RE: LP-22-00003 Haybrook Farms Ph 3

RE: LP-22-00003 Haybrook Farms- Building & Fire Code Comments

**TO:** All Staff  
**FROM:** Public Works Plan Review Team  
**DATE:** August 9, 2022  
**SUBJECT:** LP-22-0003 Haybrook Farms Ph3

HAYBROOK FARMS PHASE 3
PART OF SECTION 30, T. 18 N., R. 19 E., W.M.
KITITAS COUNTY, WASHINGTON
- PRELIMINARY PLAT -

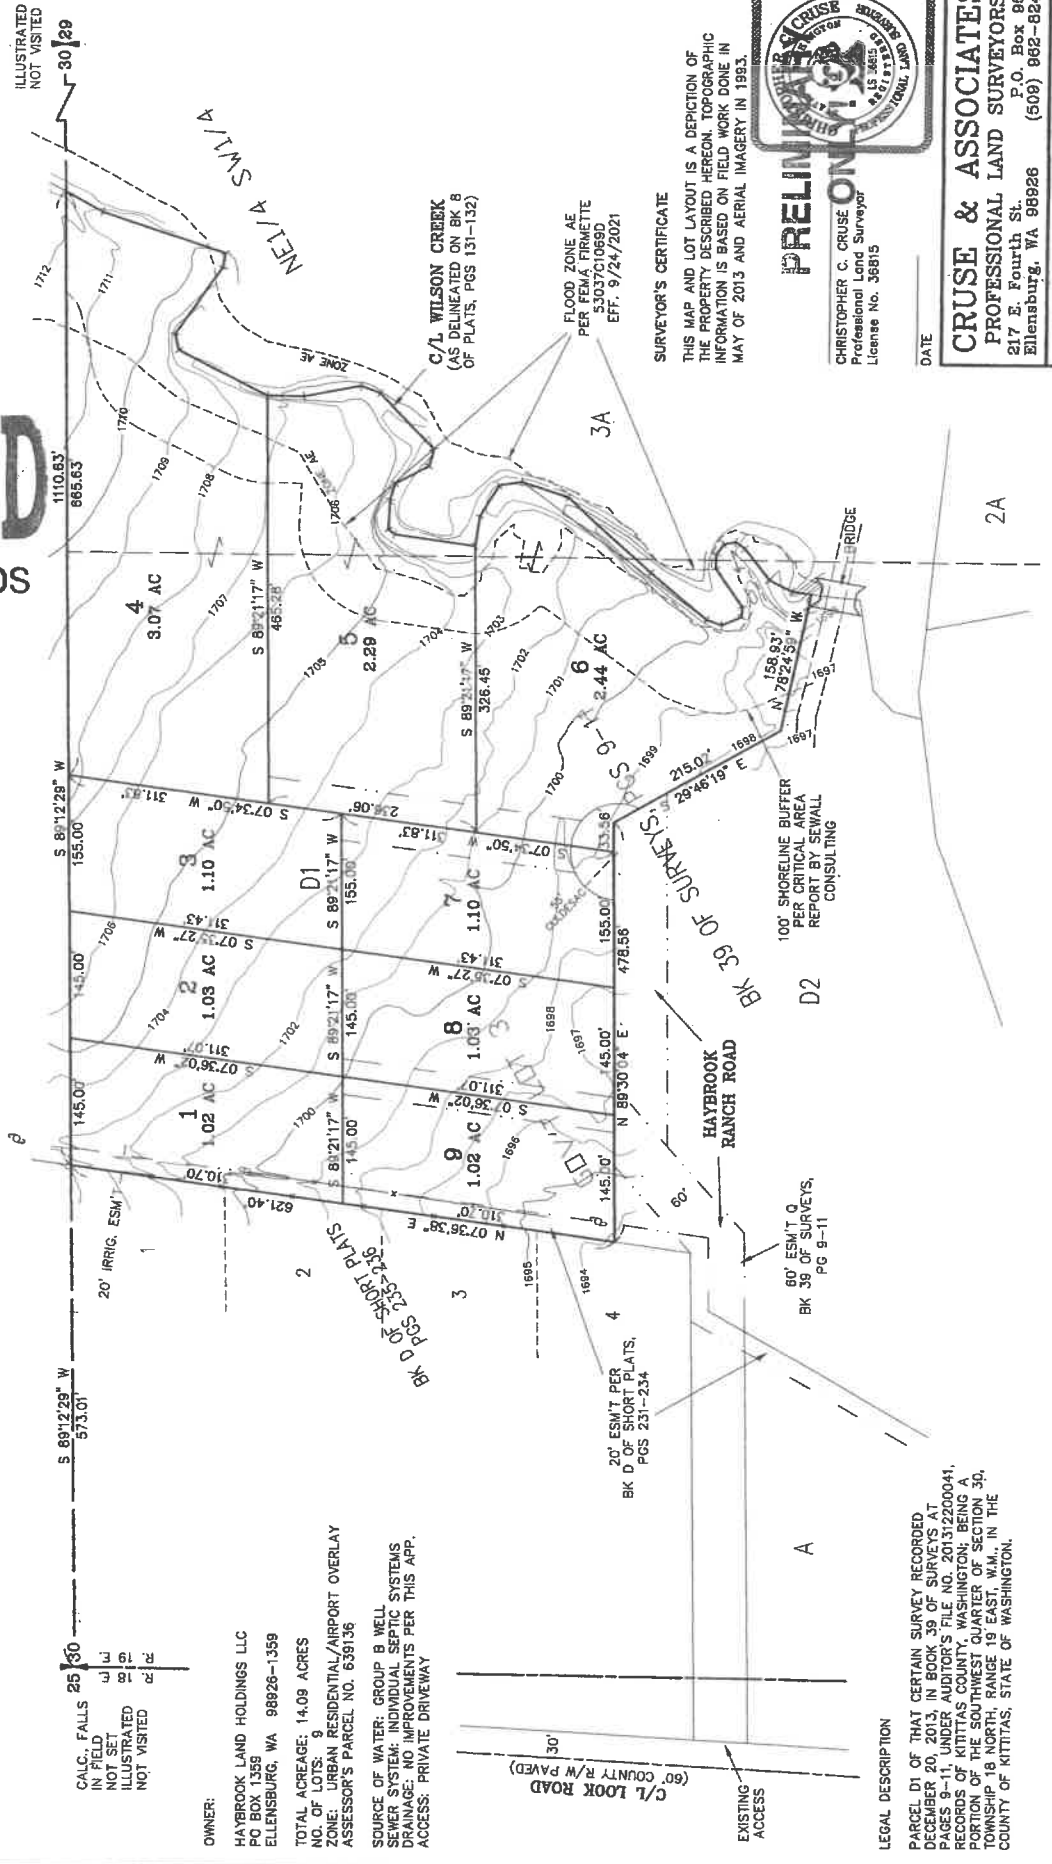
<p><b>SURVEY</b></p>	<ol style="list-style-type: none"> <li>1. Submitted application does not meet the requirements of WAC:332-130-145 in regards to vertical datum, basis of bearing, benchmarks used, source of contours, etcetera.</li> <li>2. There is no Engineer of Record on the face of the Prelim Plat.</li> </ol> <p>Prior to approval of the Final Plat, the following issues will need to be addressed:</p> <ol style="list-style-type: none"> <li>1. The legal description is not coincident with the title report.</li> <li>2. Controlling corners will need to be noted, and property corners set.</li> <li>3. The boundaries along Wilson Creek will need to be delineated.</li> <li>4. The access easements will need to be labelled, and the new access easement outside the plat boundaries will need to be dedicated via separate easement.</li> <li>5. Lot closures will need to be submitted.</li> </ol>
<p><b>FLOOD</b></p>	<p>The applicant has correctly noted that a portion of lots 4, 5, and 6 of the proposed plat would be located in the 100-year floodplain.</p> <p>Per KCC 14.08.220, all subdivisions as well as new development shall:</p> <ol style="list-style-type: none"> <li>1. Be consistent with the need to minimize flood damage.</li> <li>2. Have public utilities and facilities such as sewer, gas, electrical, and water systems located and constructed to minimize flood damage.</li> <li>3. Have adequate drainage provided to reduce exposure to flood damage.</li> <li>4. Where base flood elevation data has not been provided or is not available from another authoritative source, it shall be generated for subdivision proposals and other proposed developments containing greater than 50 lots or 5 acres (whichever is lesser) and shall be included as part of the application and shall be noted on the final mylar.</li> <li>5. All subdivisions shall show on the face of both the preliminary and final plat, for either short or long plats, the boundary of the 100-year floodplain and floodway.</li> </ol>
